27 January 2023

**GQ Parramatta – Proposed Mixed Use Development SSD-35609161
12 Hassall Street, Parramatta (Site)**

NSW Police Force (NSWPF) Submission on Applicant Additional Information

Title  
B-GENERAL ARRANGEMENT PLANS  
**LEVEL 01 FLOOR PLAN**

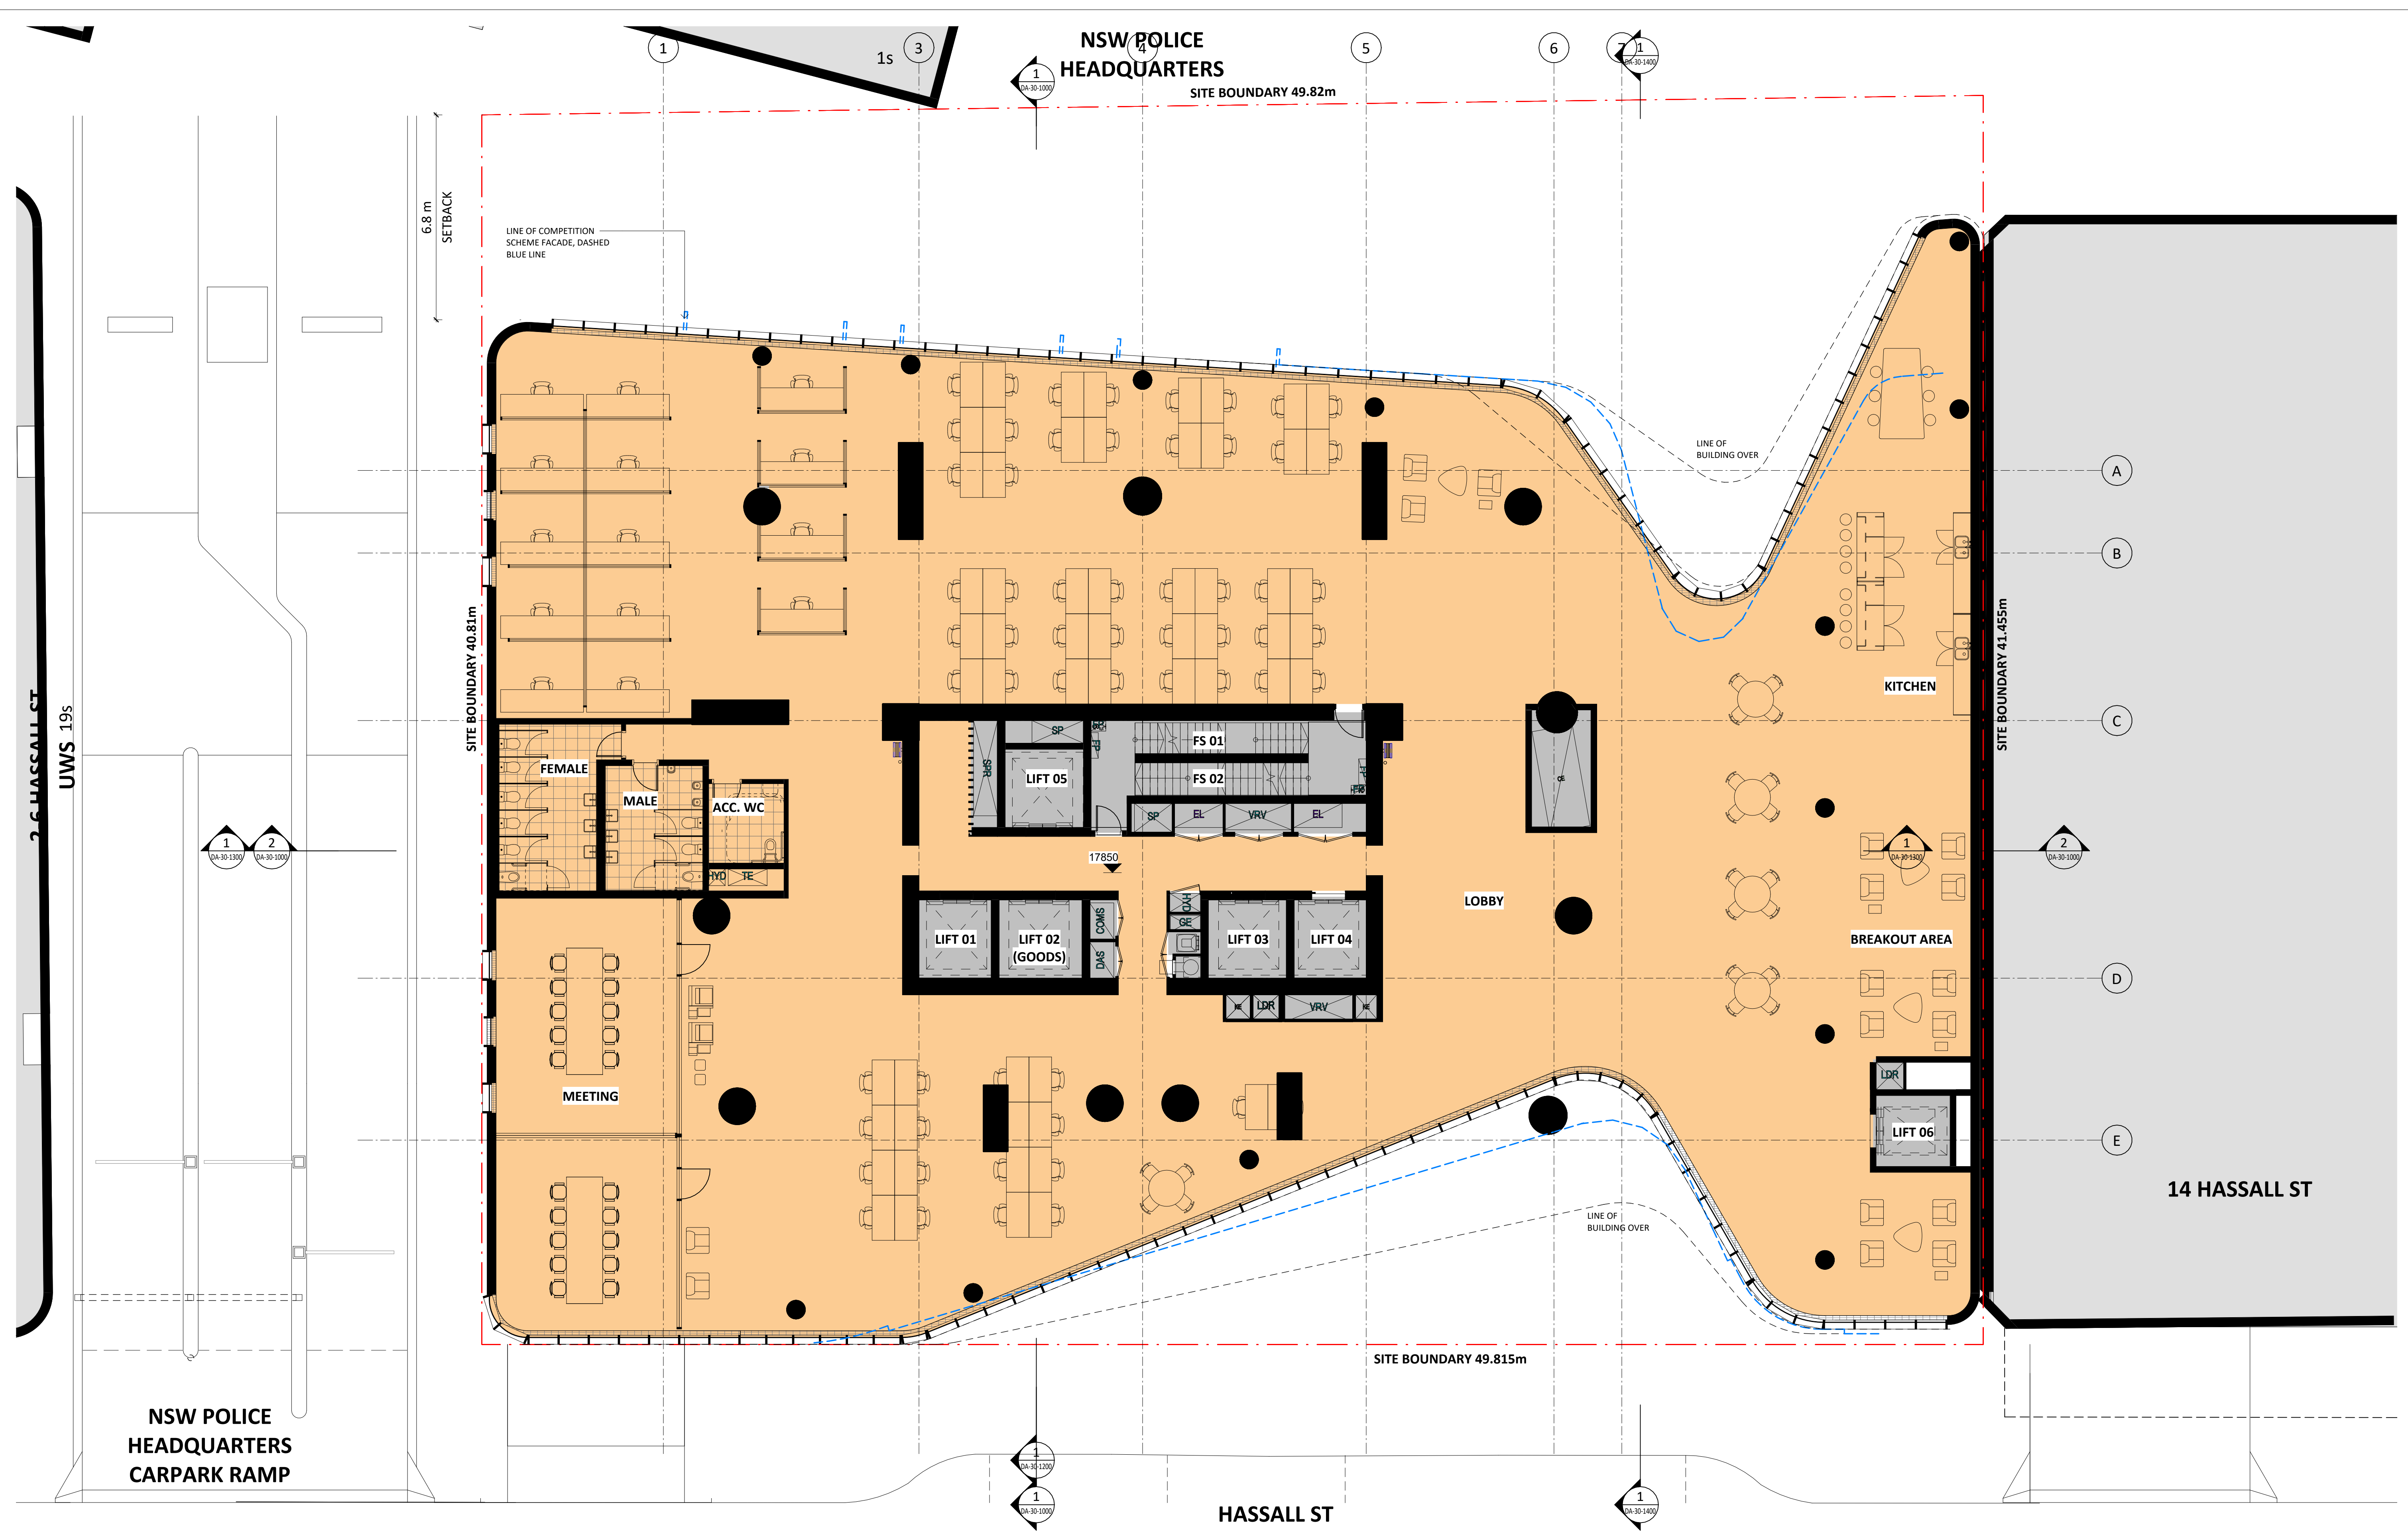
- 25 The plans submitted by the Applicant with its Response to Submissions Report in October 2022 depict a café, retail and a gym on the Ground Floor, with the gym extending to

Level 1.⁸ A gym, in particular, could attract increased non-resident vehicular traffic to the area.
